7000 Acres

7000 Acres Response to the West Burton Solar Project Ltd Application on the subject of:

Agricultural Land Classification

Deadline 1A Submission – 7th December 2023

Appendix 6 - West Burton 1

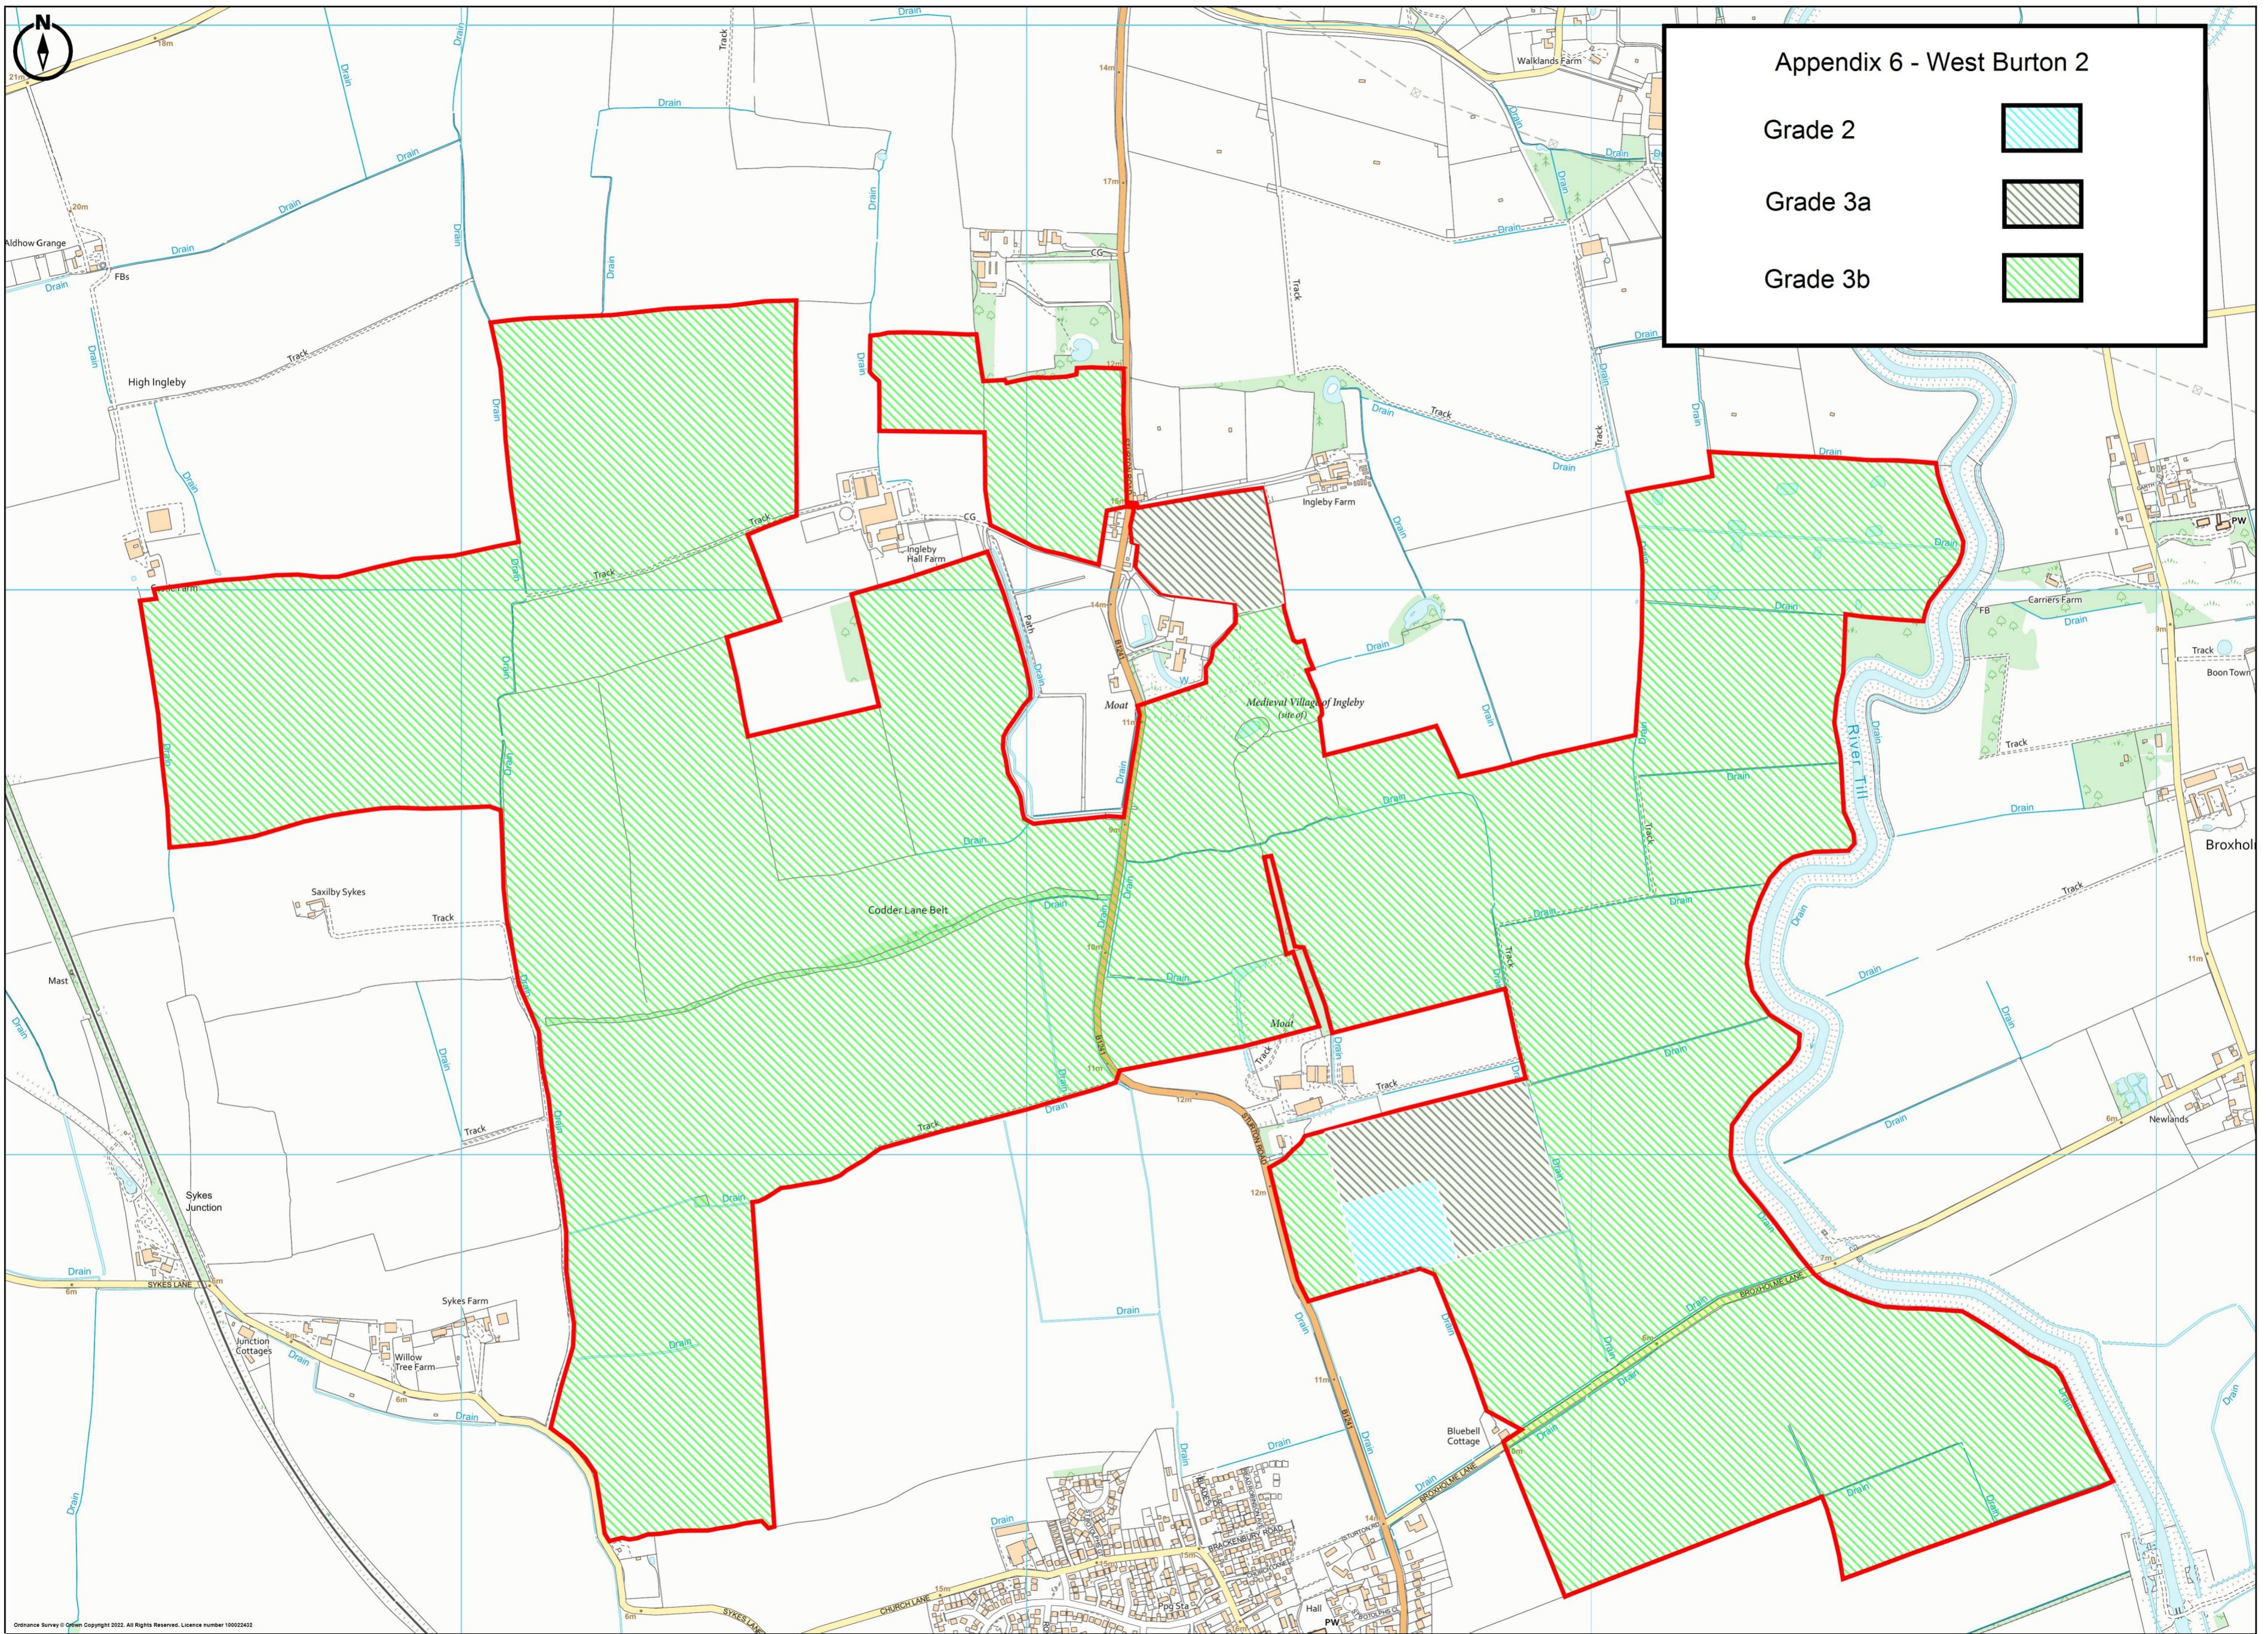
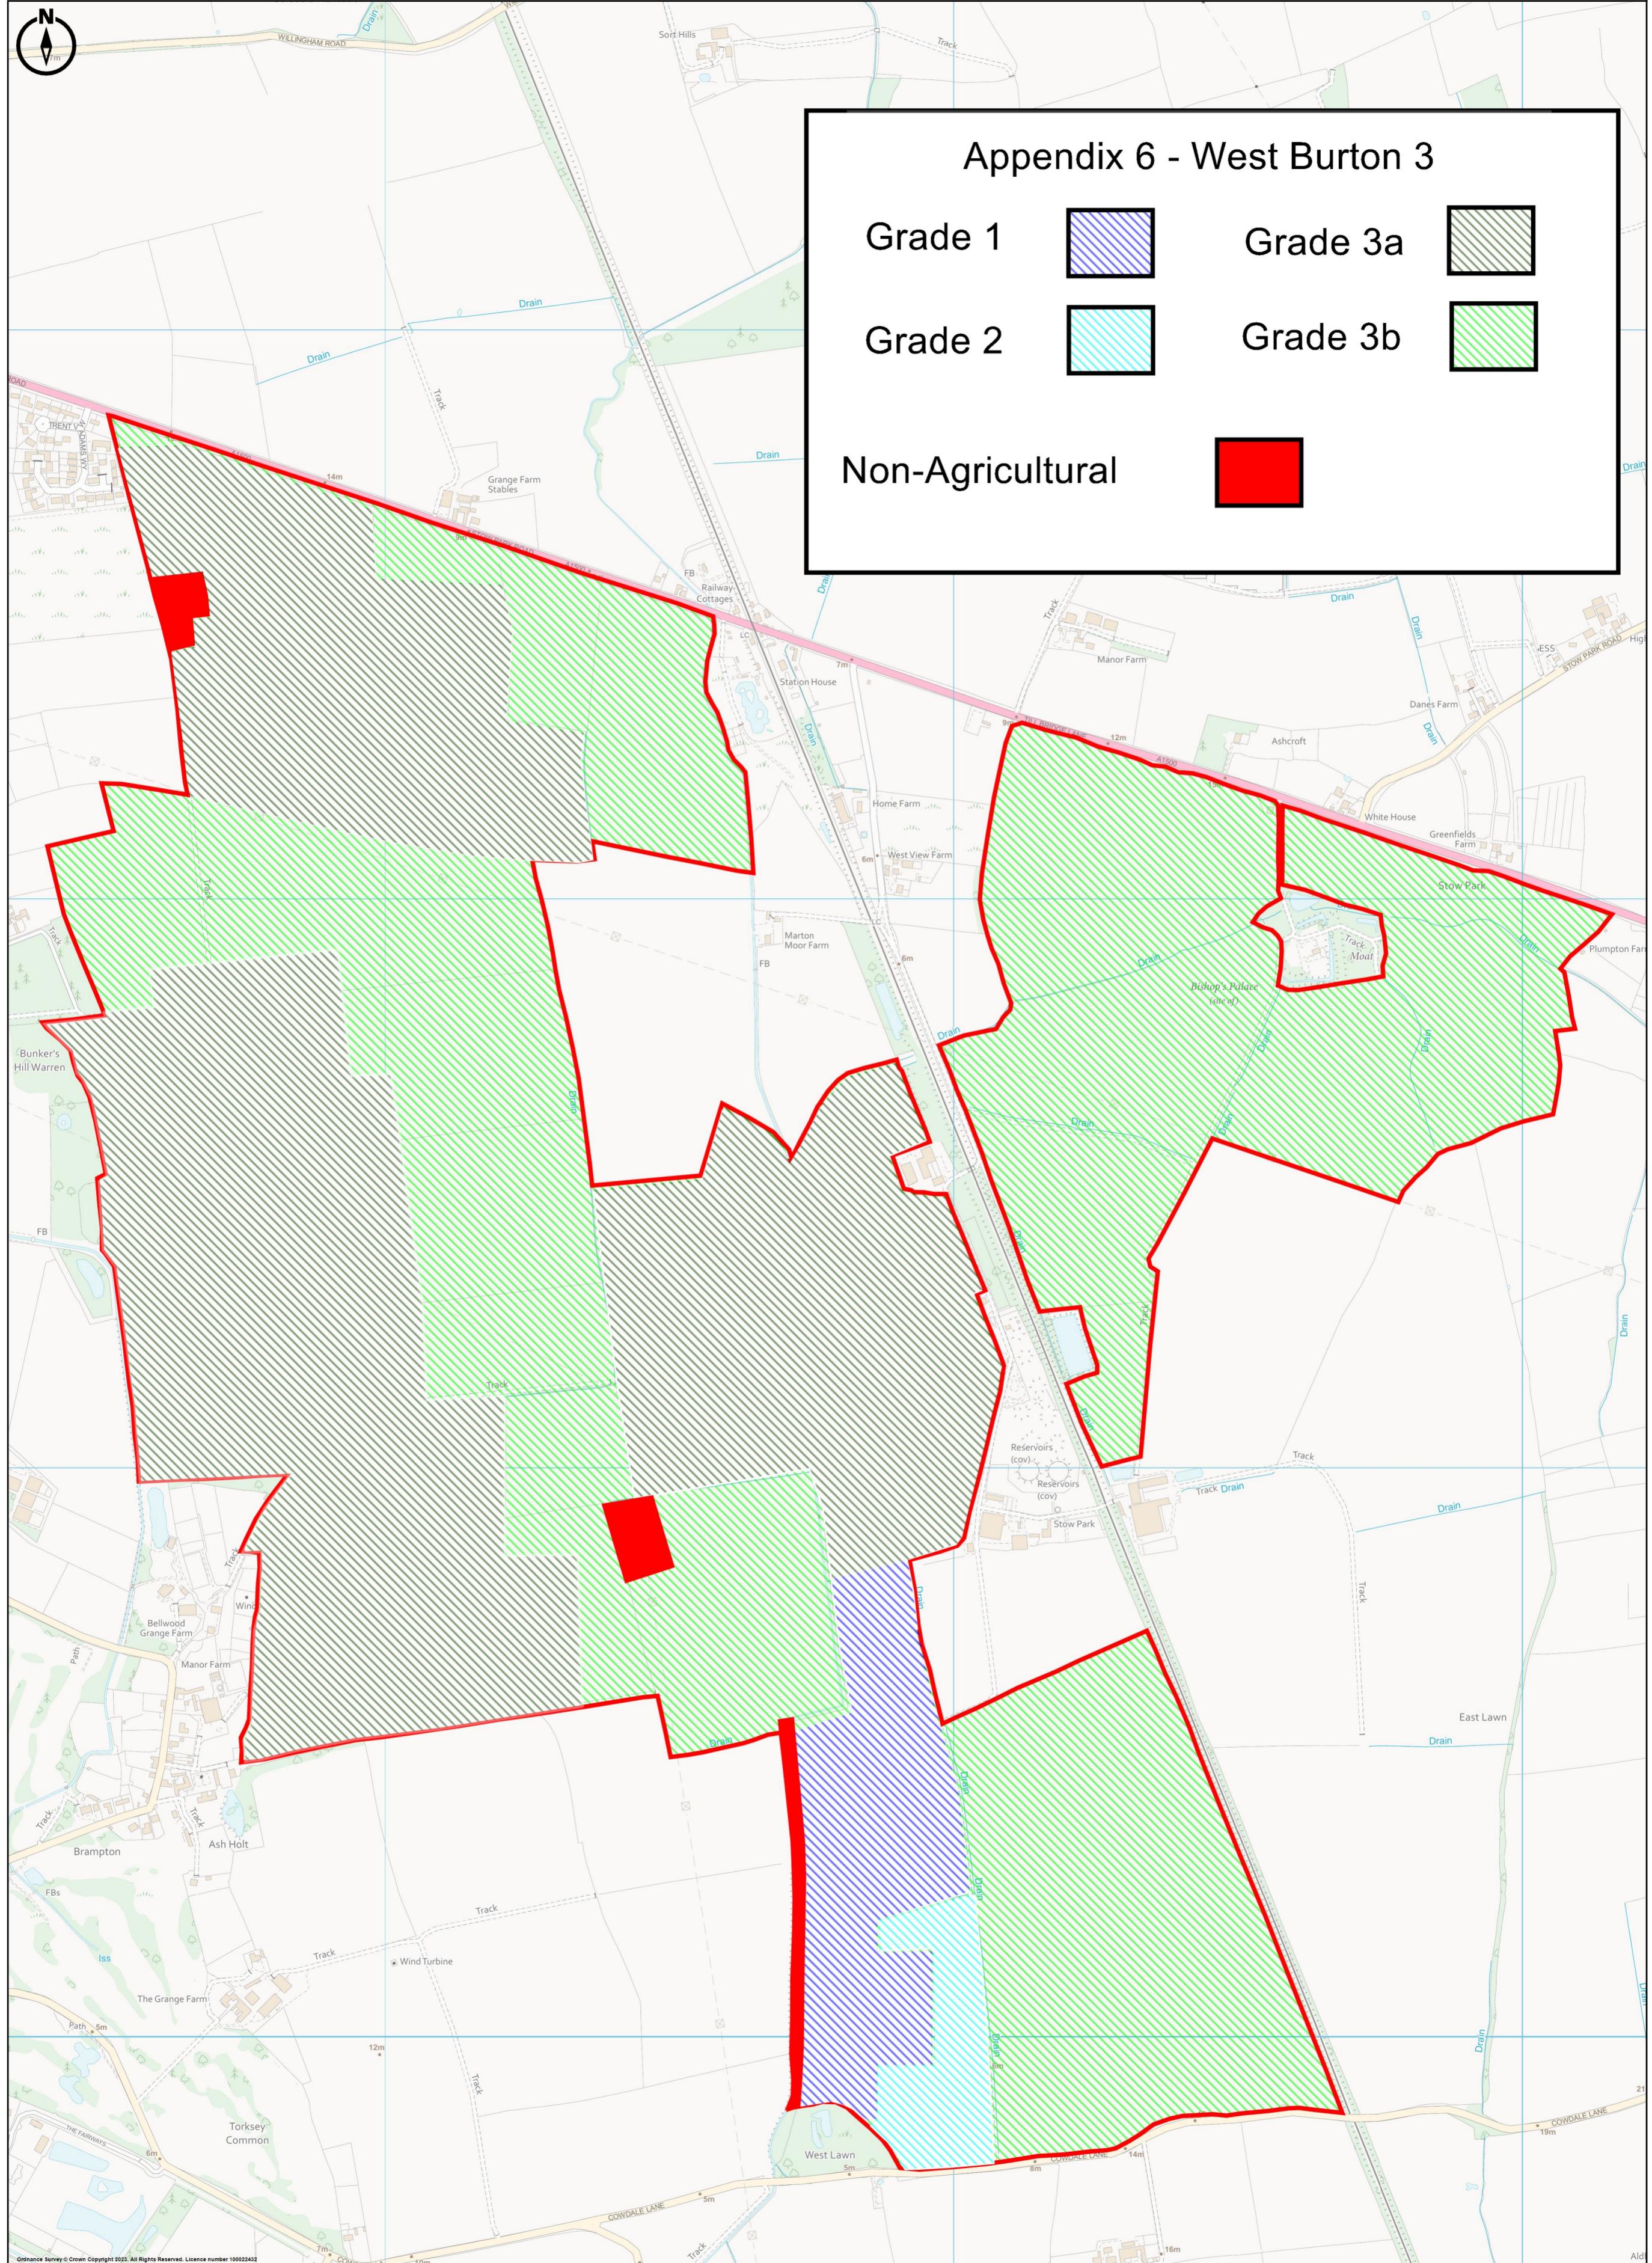
When analysing the submitted ALC data in detail, contained in APP-137 Environmental Statement, Appendix 19.1 Agricultural Land Quality, Soil Resources & Farming Circumstances March 2023, the following inconsistencies and inaccuracies can be found:

Variances of Grade with similar data results:

Sample	Grade	Sample	Grade
450, 451	2	295, 306, 307, 308, 309, 322, 323, 324, 325, 326, 327, 336, 337, 338, 339, 340, 341, 342, 343, 344, 353, 354, 355, 356, 357, 359, 360, 366, 367, 368, 369, 371, 372, 373, 374, 375, 376	3b

Sample	Grade	Sample	Grade
391, 469	3a	386, 387, 388, 392, 393, 394, 395, 396, 397, 407, 408, 409, 415, 416, 417, 418, 419, 429, 430, 440, 448	3b
968, 998, 1009	3a	759, 760, 774, 775, 795, 796	3b
335	2	334, 597, 605, 613	3b
979, 980, 981, 982, 993, 994	3a	966, 967	3b

The classification of some of the samples has been downgraded based upon allocating the samples to the Wetness category III criteria. The field capacity of the soils shows this categorisation can be very marginal.

In addition to these records there are 96 samples with missing data in their field records or inaccuracies. A further 36 samples have inconsistencies in their field records. That is **216 records** that require further investigation and adjustment out of a total of **829 samples** i.e. **26% errors**.
